Appeal Decision

Appeal Ref: 6005823

223 Wakefield Road, Dewsbury WF12 8ER

- The appeal is made under section 78 of the Town and Country Planning Act 1990 (as amended) against a refusal to grant planning permission.
 - The appeal is made by Mr Y Bhayat against the decision of Kirklees Metropolitan Council.
 - The application Ref is 2025/62/92804/E.
 - The development proposed is a first floor extension over side extension.
-

Proposed West Elevation. Scale 1:100 (Front side)

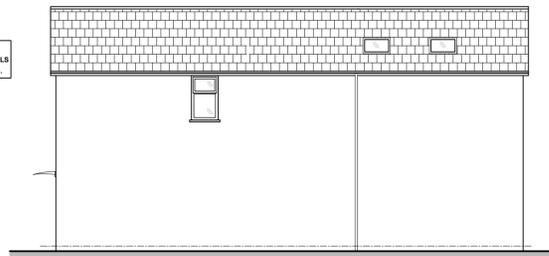
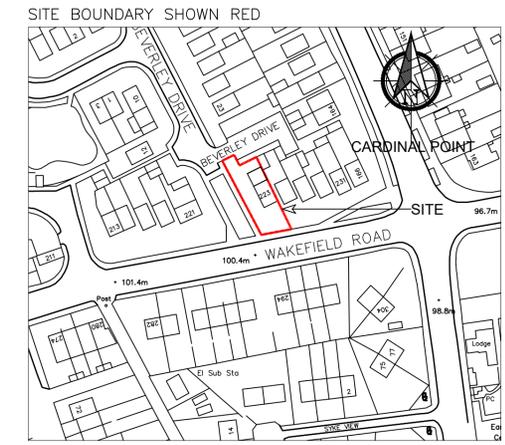
7. Due to the excessive width of the proposed first floor extension combined with its lack of setback from the existing building line or set down from the roof ridge, it would appear as a bulky and dominant addition to the host dwelling. Consequently, the extended dwelling would appear excessively wide and out of scale with the other dwellings in the group. Accordingly, the extension would appear as an incongruous addition to the host dwelling and would harmfully contrast with the regular order and scale of the dwellings nearby.

8. Even though the front elevation of the property does not face Wakefield Road, this does not justify the proposed first floor extension, given that it would still appear discordant when viewed from the footpath to the front of the property and from the rear on Beverley Drive. Furthermore, the use of matching materials would not be sufficient to successfully integrate the extension with the host dwelling and its surroundings.

PROPOSED FIRST FLOOR PLAN, SCALE 1:50

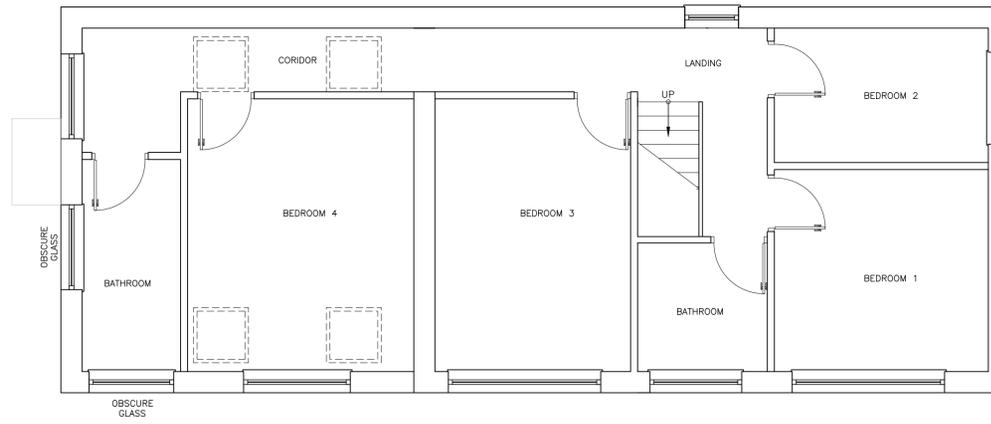
12. Even though the proposed first floor extension would follow the footprint of the existing ground floor extension, due to its additional height together with its close proximity to the side boundary with No 225, it would have a harmful enclosing effect when experienced from habitable rooms which are served by windows on the rear elevation of the neighbouring property. It would similarly enclose the rear garden of No 225. Consequently, the extension would have an overbearing effect when experienced from habitable rooms on the rear elevation and from the rear garden area of the neighbouring property. For the same reasons, it would also result in a reduction of ambient daylight to these areas.

BLOCK PLAN (PROPOSED), 1:200

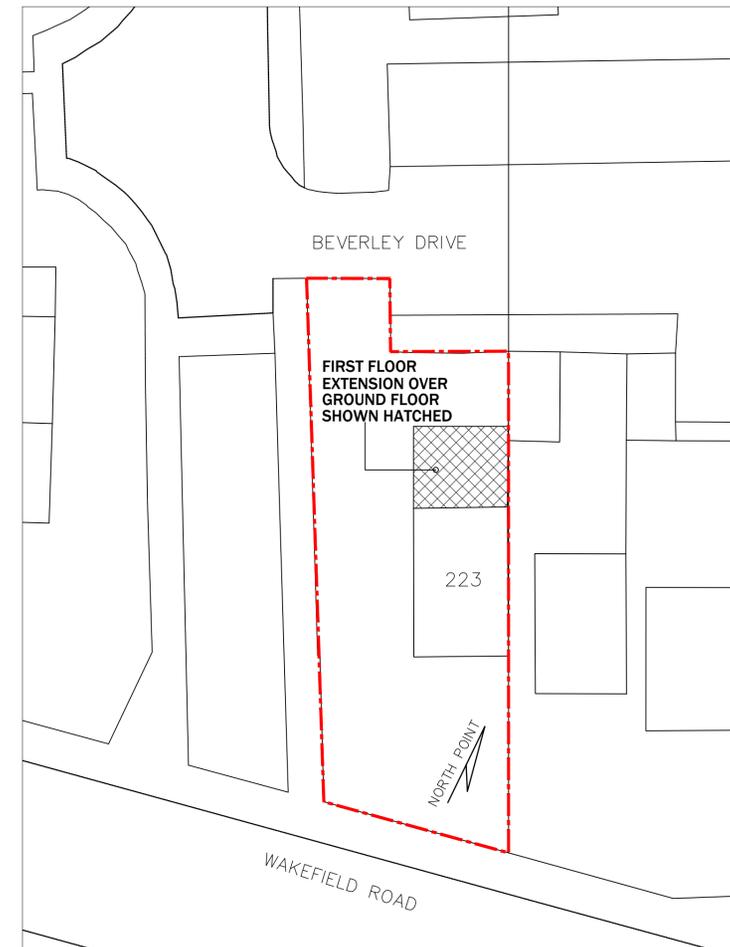
13. With regards to the effect of the proposed first floor extension on direct sunlight to No 225, the Location Plan indicates that the extension would be sited to the north-west of the neighbouring property. Therefore, any loss of direct sunlight would be limited to at the end of the day only. Although this would not be significantly harmful in itself, it does not justify the harm in terms of outlook and ambient daylight.
